HINCKLEY NATIONAL RAIL FREIGHT INTERCHANGE

Project reference TR050007

Signposting for Resubmission

Signposting to amendments made to application documents

Figure 12.1: Statutory Designated Sites (Sheet 1 of 2)

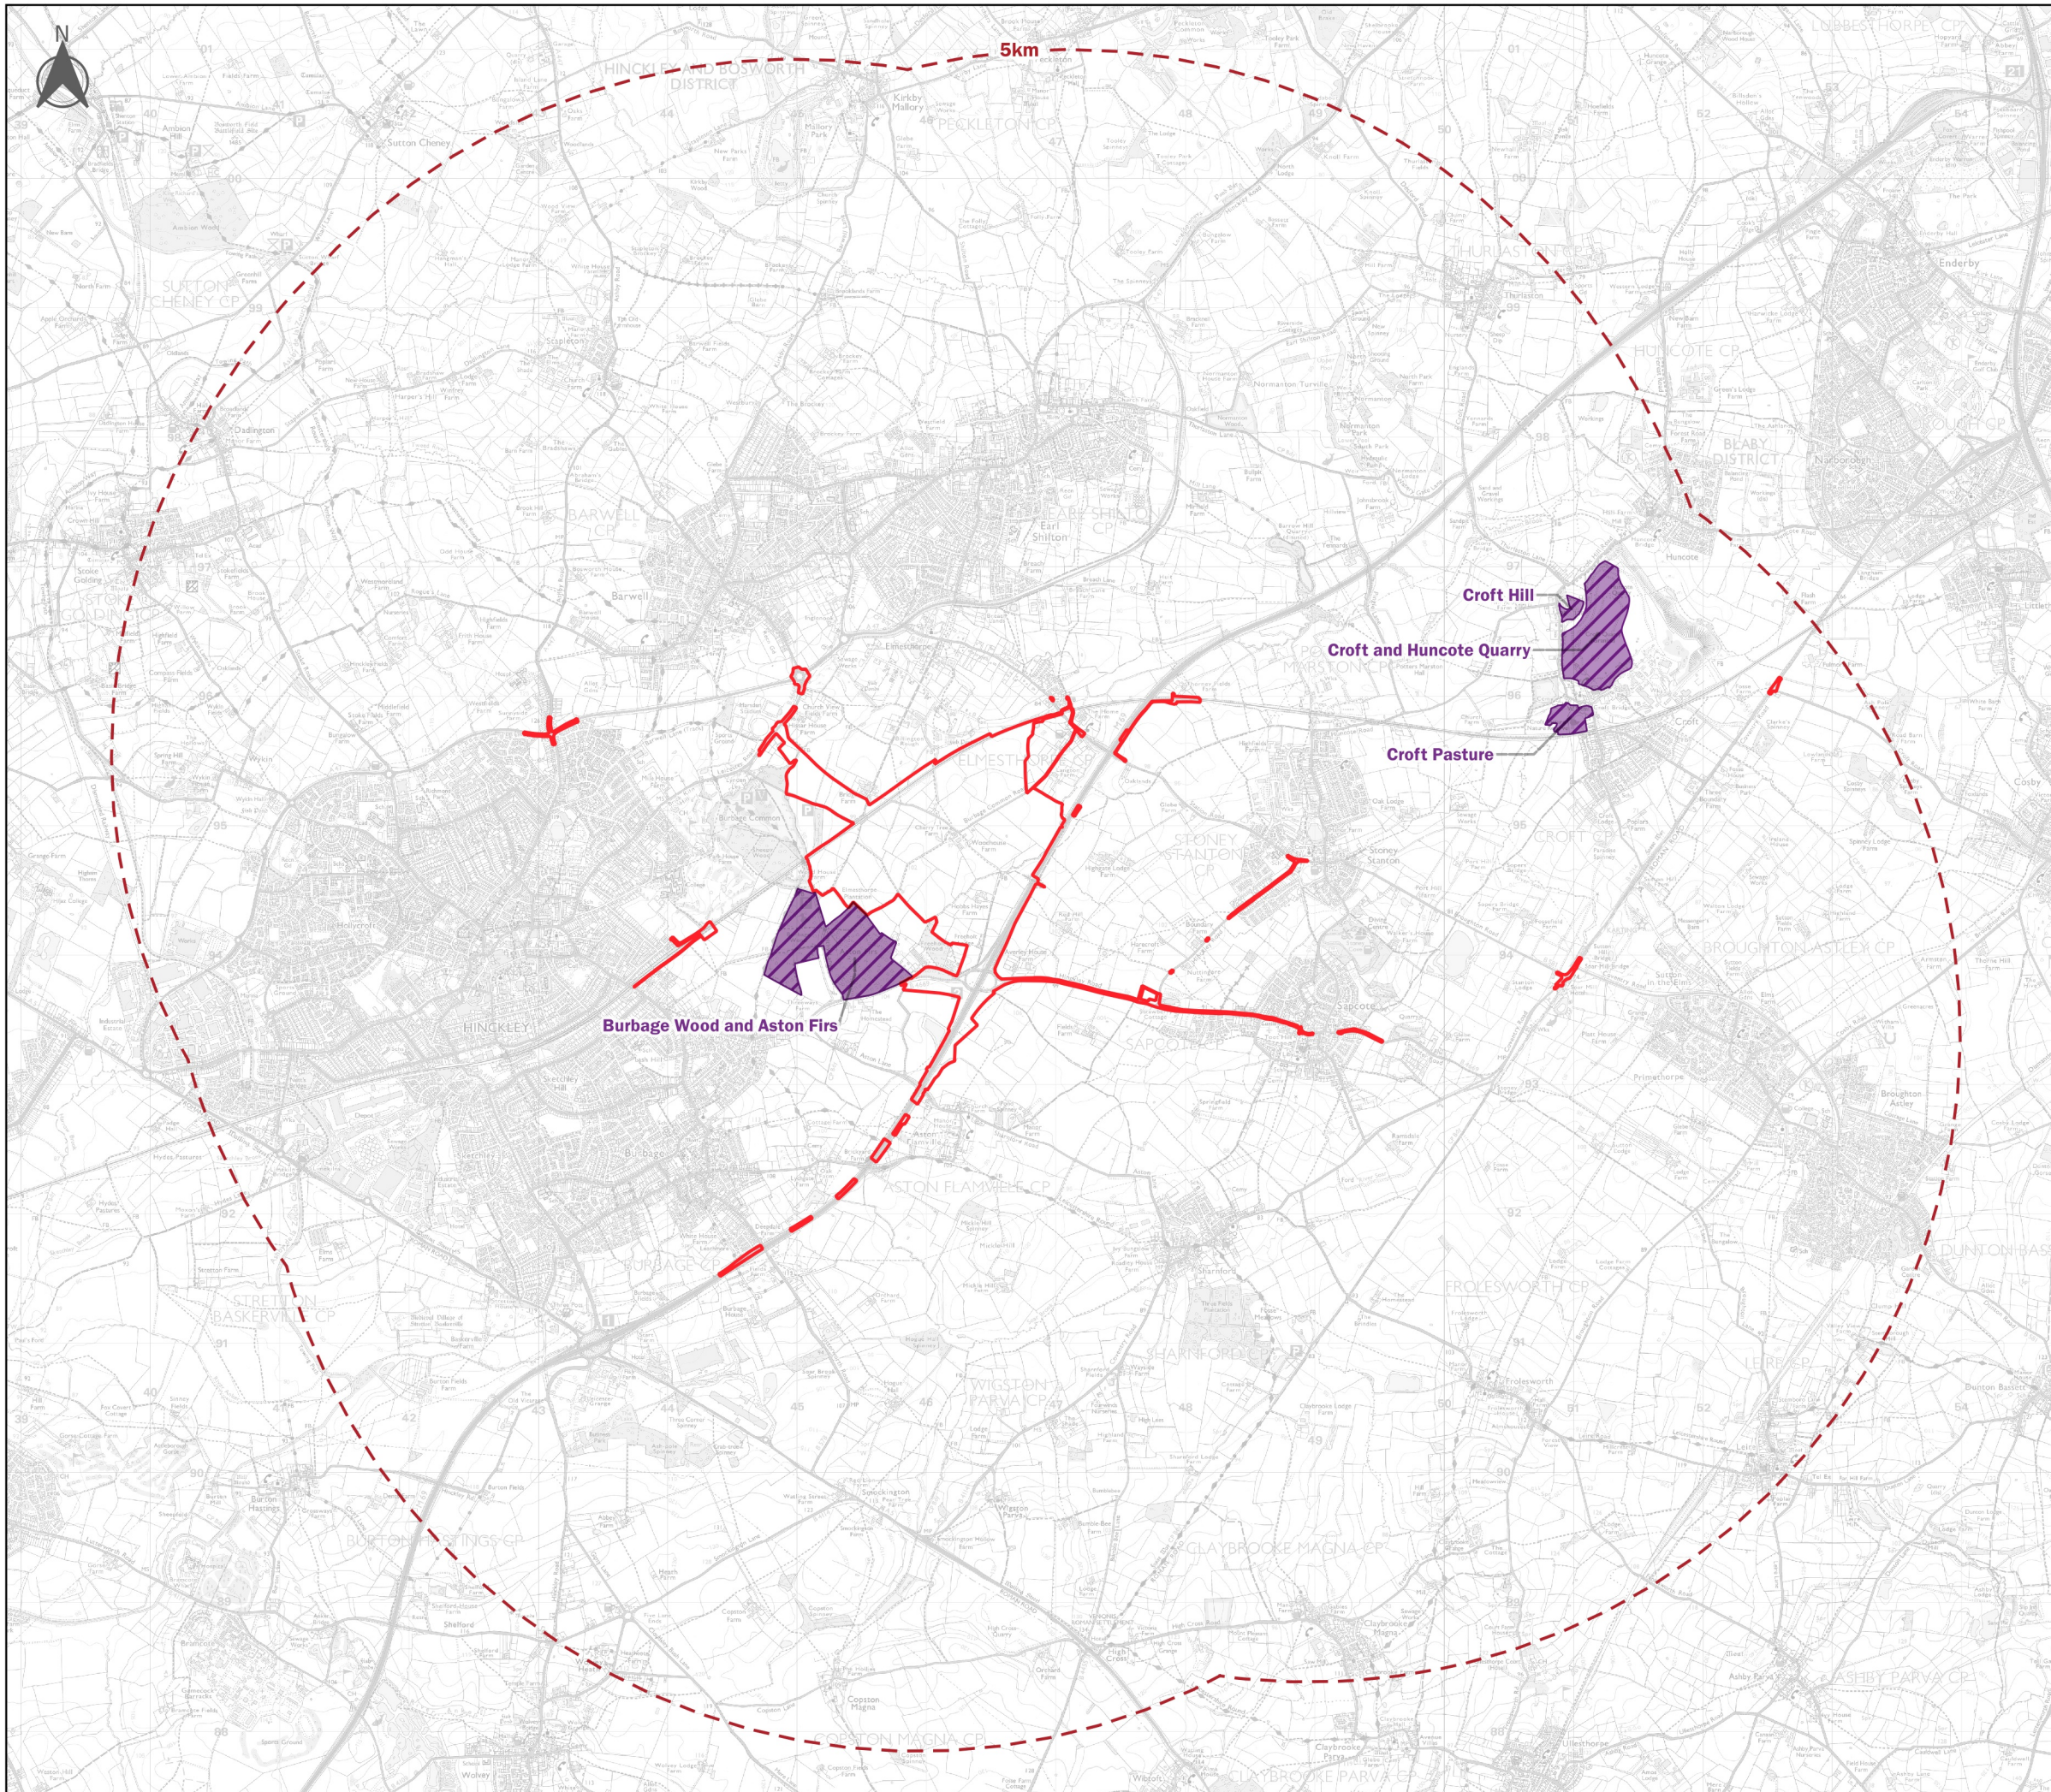
| PINS Advice | Applicant Response | Acceptance or Examination Matter |
|--|--|----------------------------------|
| 5.2 ES Figure 12.1 Statutory Designated Sites does not show the Special Areas of Conservation screened into the Shadow Habitats Regulation Assessment (sHRA) (Appendix 12.3 of the ES) and the sHRA also does not provide a figure showing the location of the relevant habitat sites cited. | As above. | Acceptance |
| 5.3 The Applicant must provide a plan identifying European statutory designated sites. | As above. | Acceptance |

| PINS Advice | Applicant Response | Acceptance or Examination Matter |
|---|---|----------------------------------|
| <p>5.1 Regulation 5(2)(l) of the Infrastructure Planning (Applications: Prescribed Forms and Procedure) Regulations 2009 (the APFP Regulations) requires:</p> <p>“Where applicable, a plan with accompanying information identifying:-</p> <p>(i) any statutory or non-statutory sites or features of nature conservation eg sites of geological or landscape importance;</p> | <p>The Applicant acknowledges that the plan previously included with the Application identifying statutory or non-statutory sites or features of nature conservation e.g. sites of geological or landscape importance (Figure 12.1 of the Environmental Statement) did not identify the Special Areas of Conservation. This plan has been updated for the re-submitted Application and the updated plan is attached at Annex 1 of the Shadow HRA.</p> | <p>Acceptance</p> |
